MEMORANDUM

TO: All Staff
FROM: Justin Turnbull, County Surveyor 
DATE: June 1, 2020
SUBJECT: County Survey Review of BL-20-00007 Mckenna

**RECORD OF SURVEY**  
PREPARED FOR  
**JOHN MCKENNA**

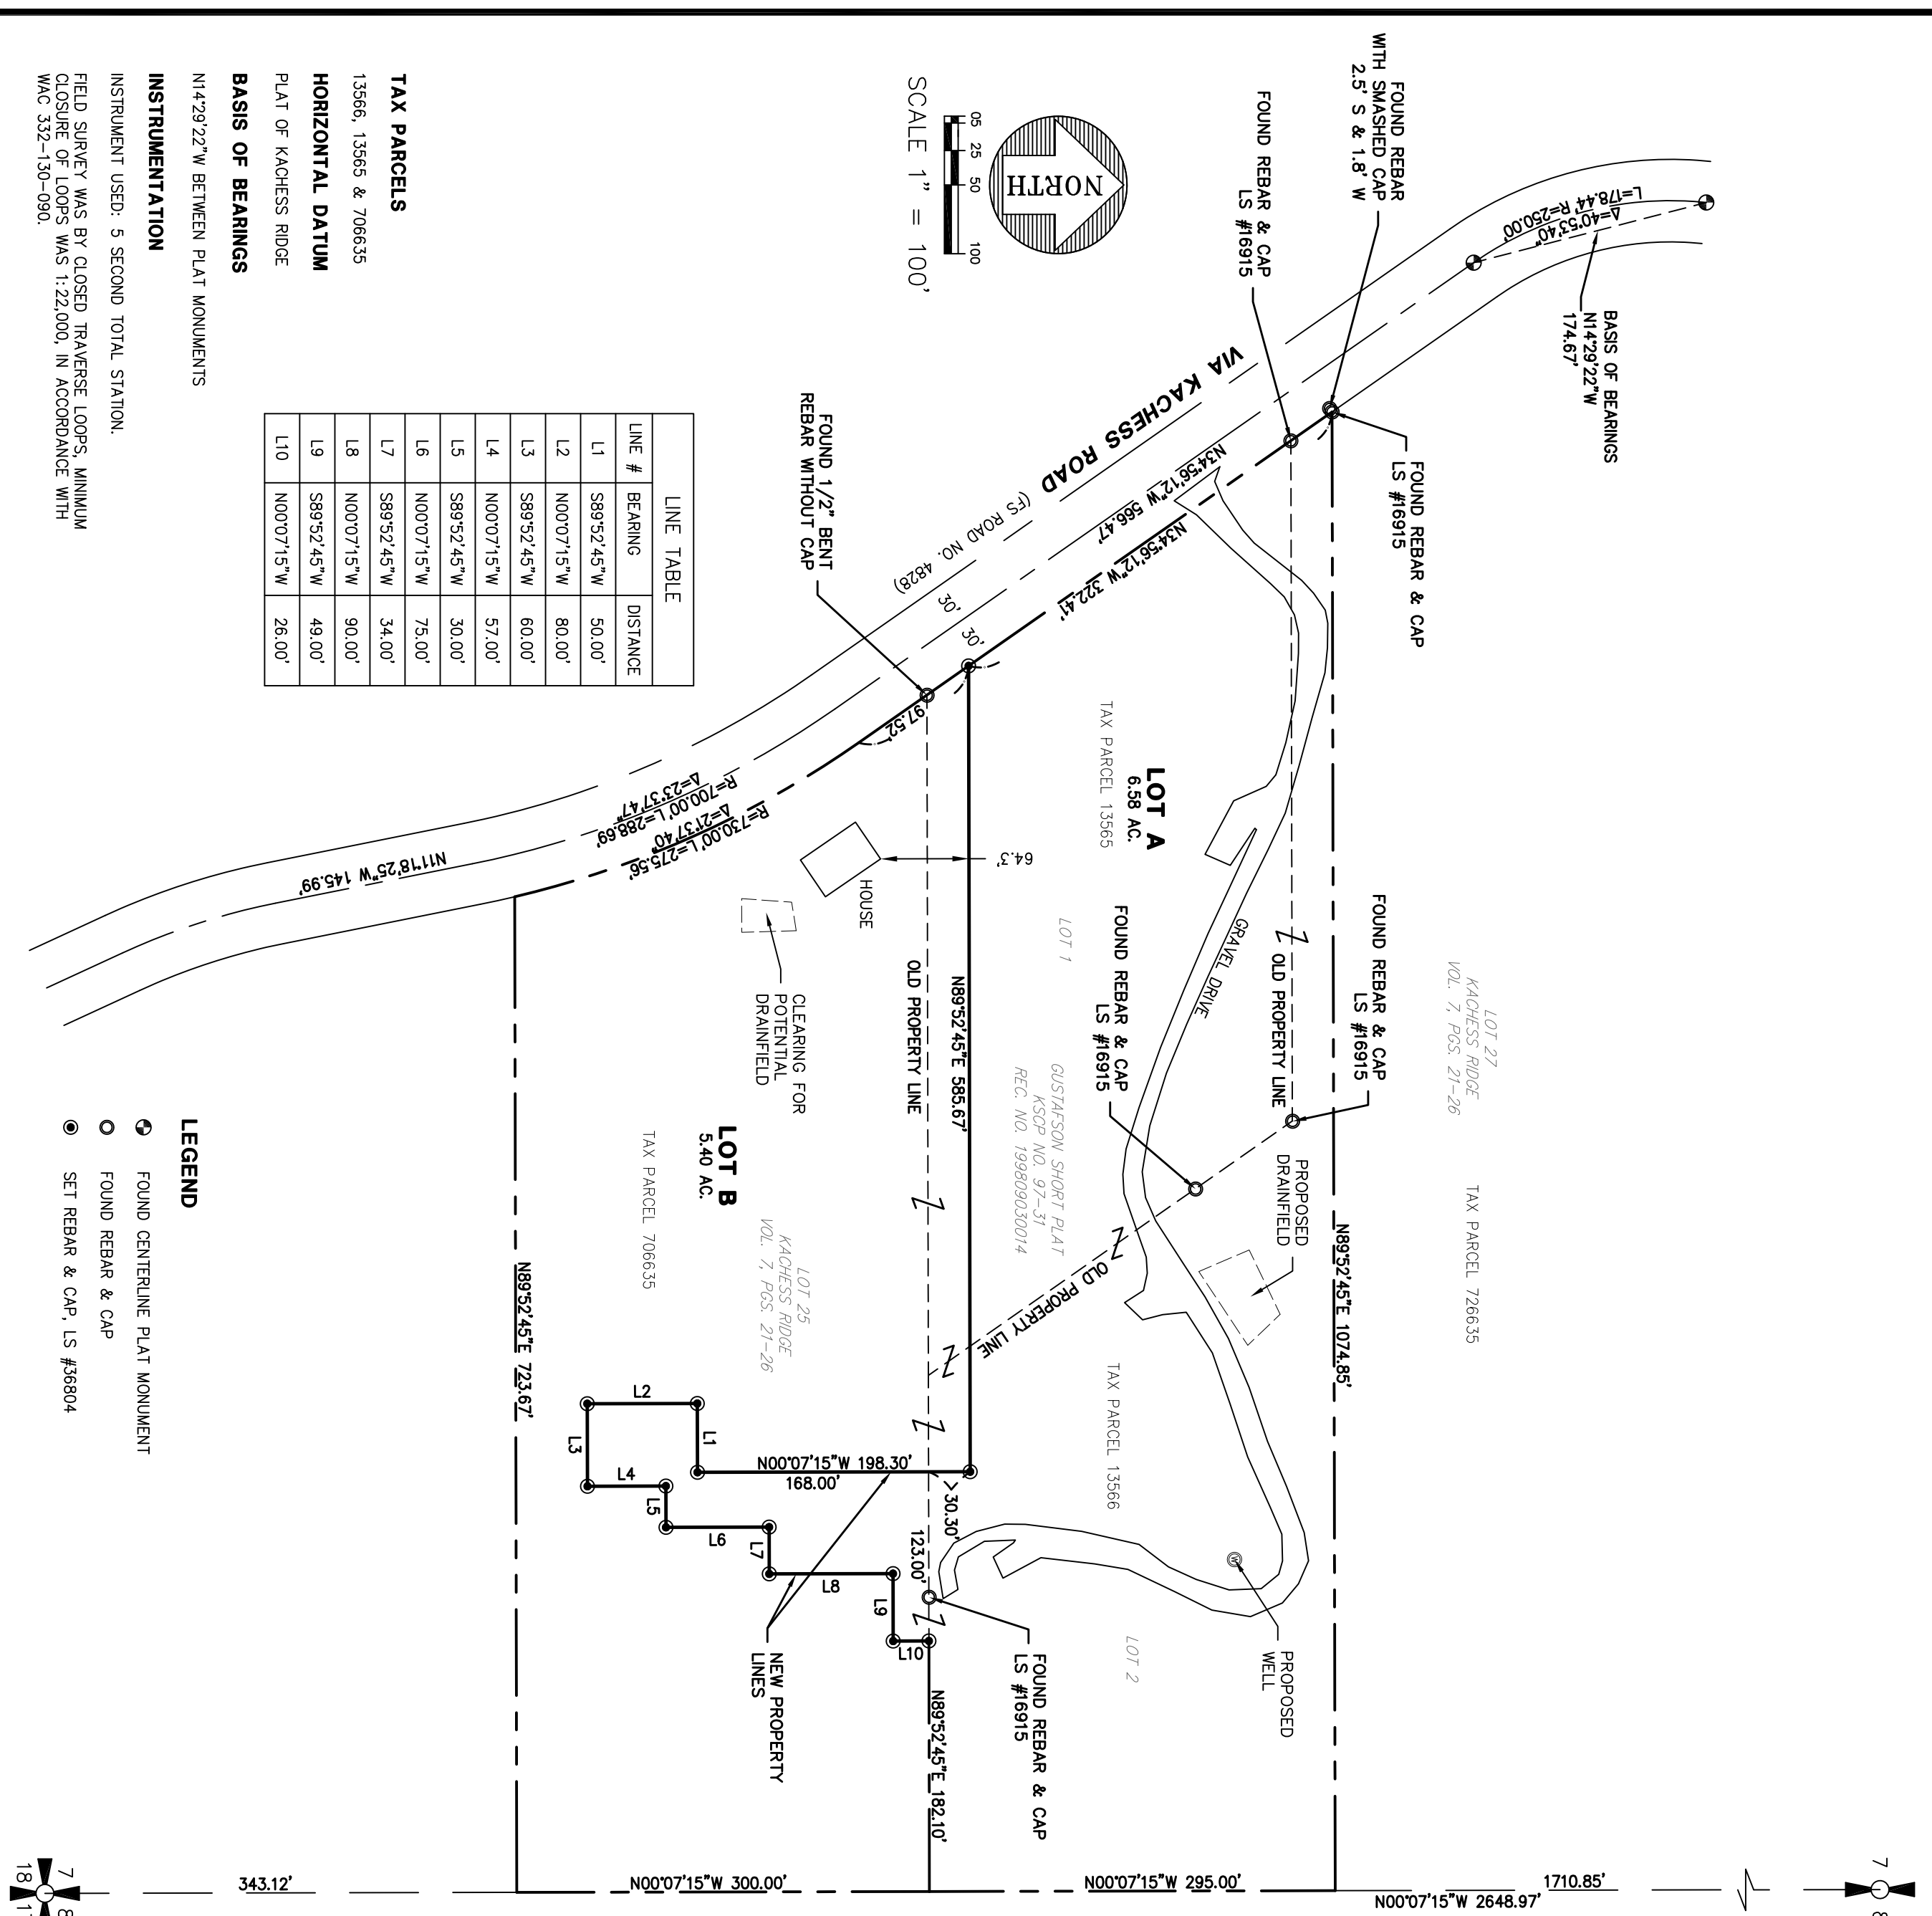
Suggestions (not required)

1. The purpose of survey statement is missing
2. Road width/ownership and surfacing information should be included.
(example: Via Kachess Rd – County R/W – Paved)
3. The section corners as shown are not described. Please include a note as to whether these were found or just calc positions.
4. Under “New Legal Descriptions”
Proposed Lot A.....
.....Commencing at the South~~west~~east corner of said lot 2.....

Proposed Lot B.....
..... Commencing at the North~~west~~Southeast corner of said Lot 2.....
